facsimile transmittal

To: Ric Weinschenck **From:** Mike Nugent
Fax: 766-2999 **Date:** August 20, 2002
Phone: 766-2900 **Pages:** 1
Re: 548 Island Ave. (092 A001) **CC:**

A preliminary review of the above project revealed the following deficiencies :

SITE PLAN
 AT 548 ISLAND AVENUE PEAKS ISLAND

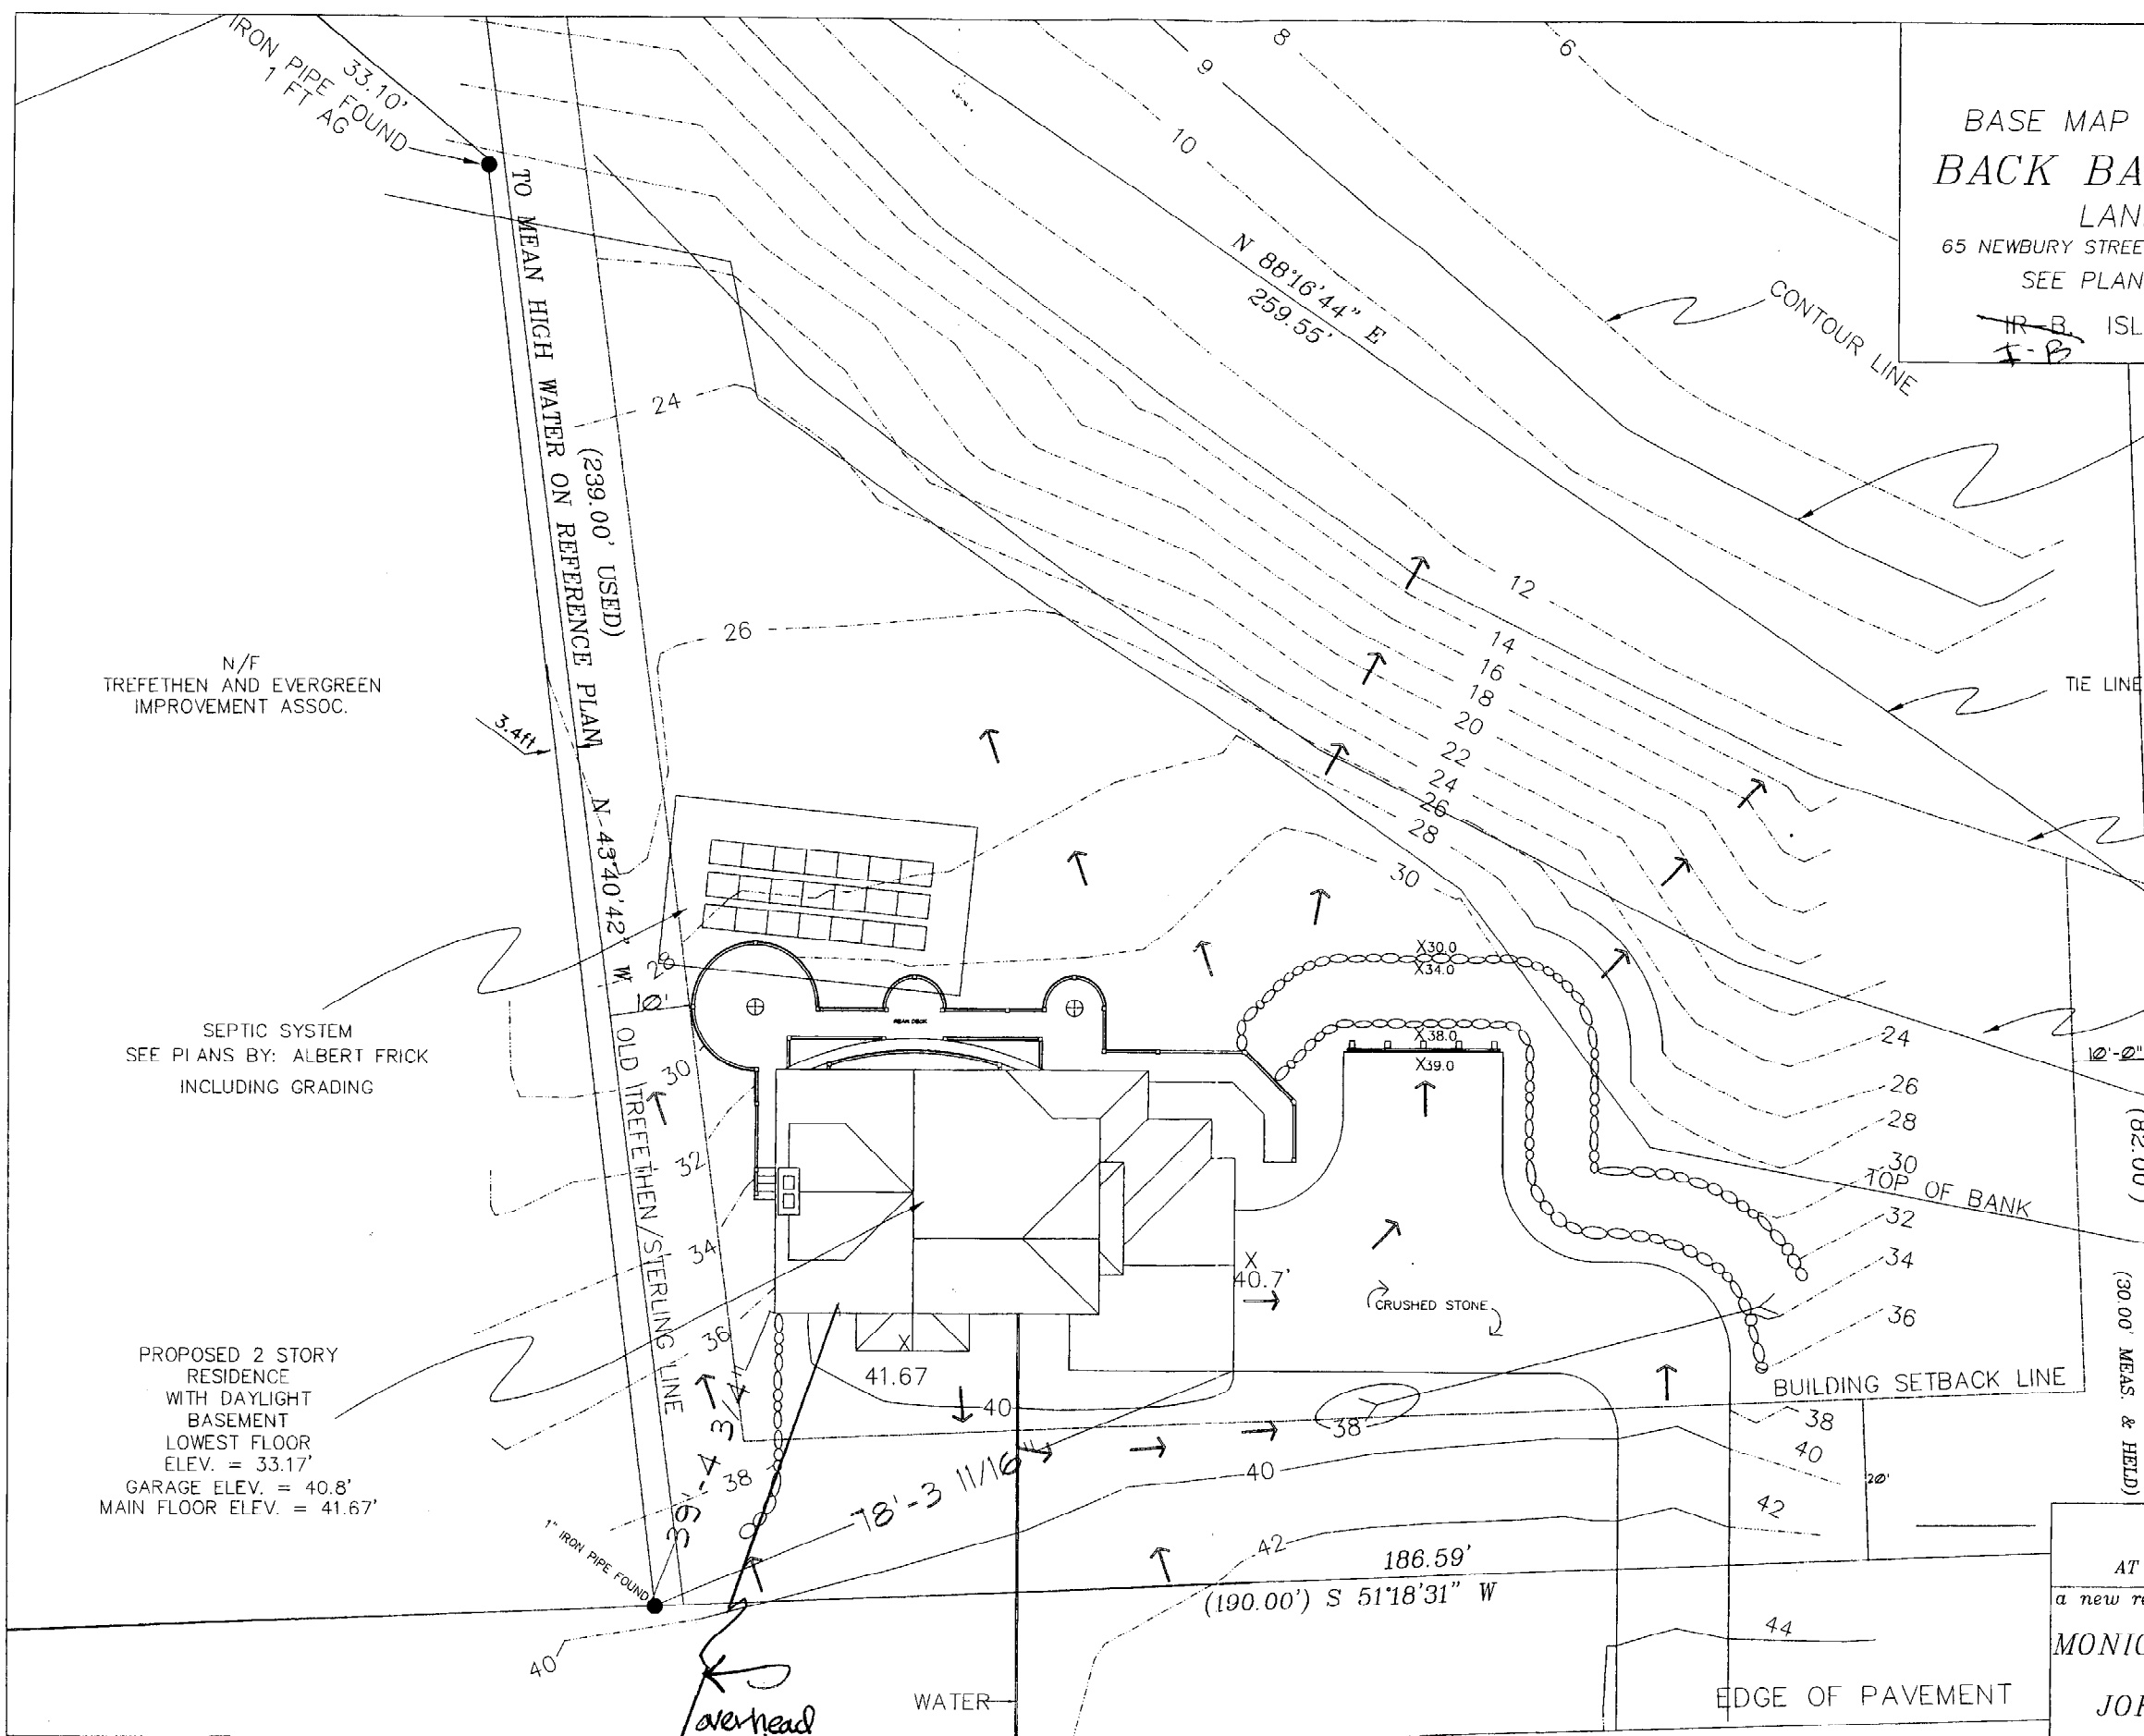
- 1) The HHE 200 form provided by Albert Frick is unacceptable, as the variances sought have been denied. Also it appears on the site plan that the structure is too close to the leach field.
- 2) The plans lack adequate structural details to establish Code compliance. Attached is a copy of the checklist used for review.
- 3) Prior to the issuance of the demo permit , an inspection must occur with a CEO, Jay Reynolds and representative from your surveying company to establish existing grade for the purpose of documenting Building Height, which will be verified by you surveyor when the roof framing is in place.
